RTI
37 Briar Close
Yapton
BN180ES

Lawful Development Certificate for a Proposed Use or Development

Development: Lawful development certificate for a proposed kitchen and dinning room extension.
Location: 37 Briar Close Yapton BN18 0ES

Front Elevation

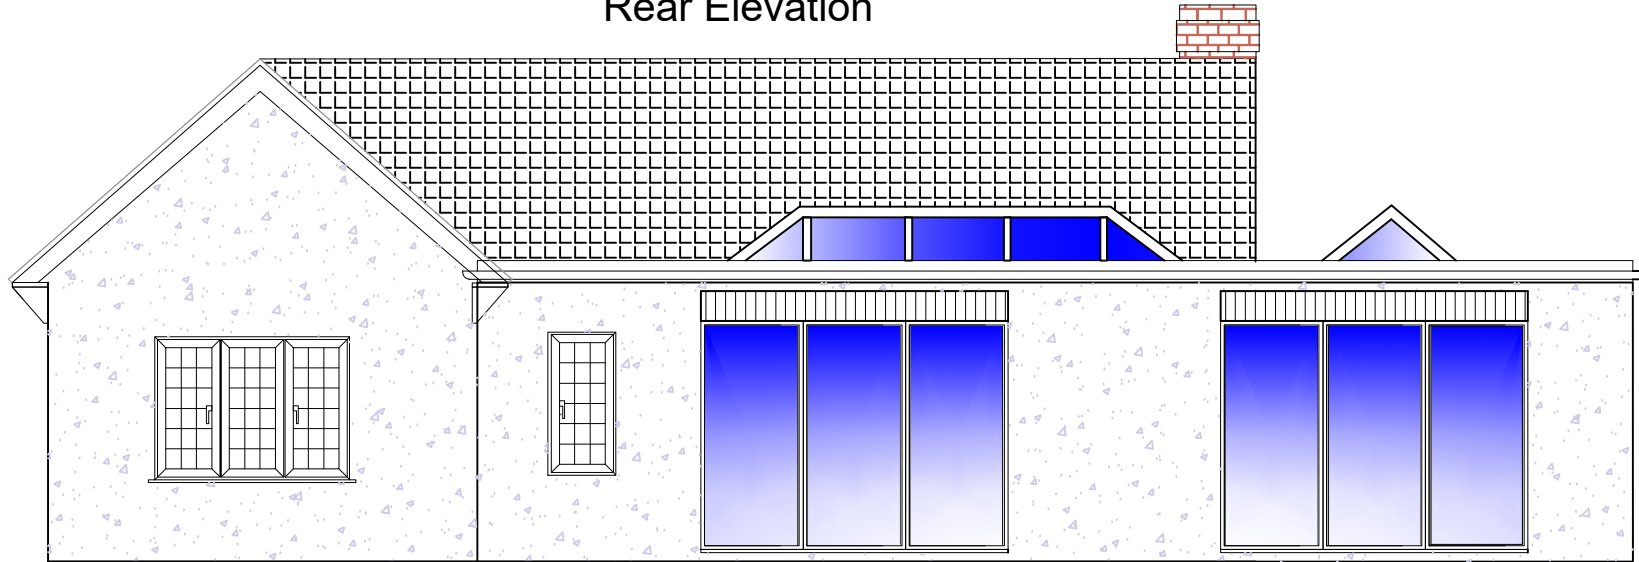
Please provide the scale or dimensions of the front and rear elevations.

Location	37 Briar Close Yapton BN18 0ES	Notes:
Reference	Proposed side 2 elevation	
Date	21/01/26	
Revision	1

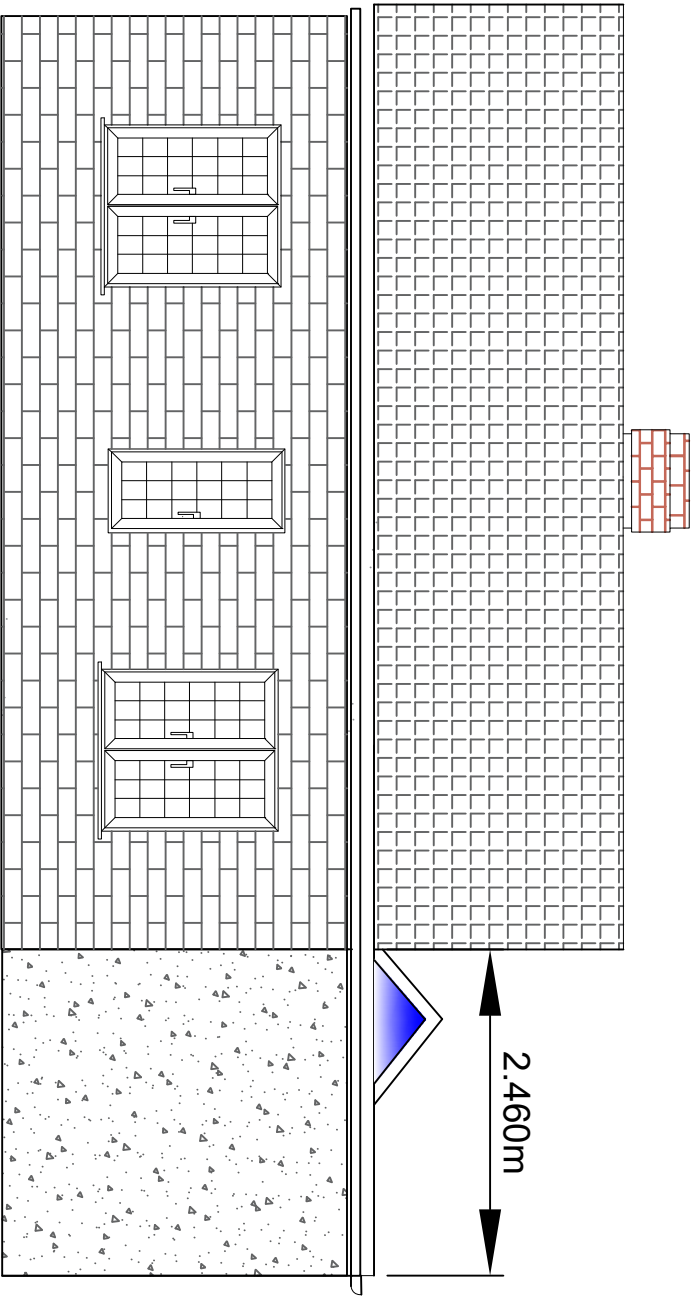
Please provide a side elevation showing the proposed extension, with either the scale of dimensions on the plan.
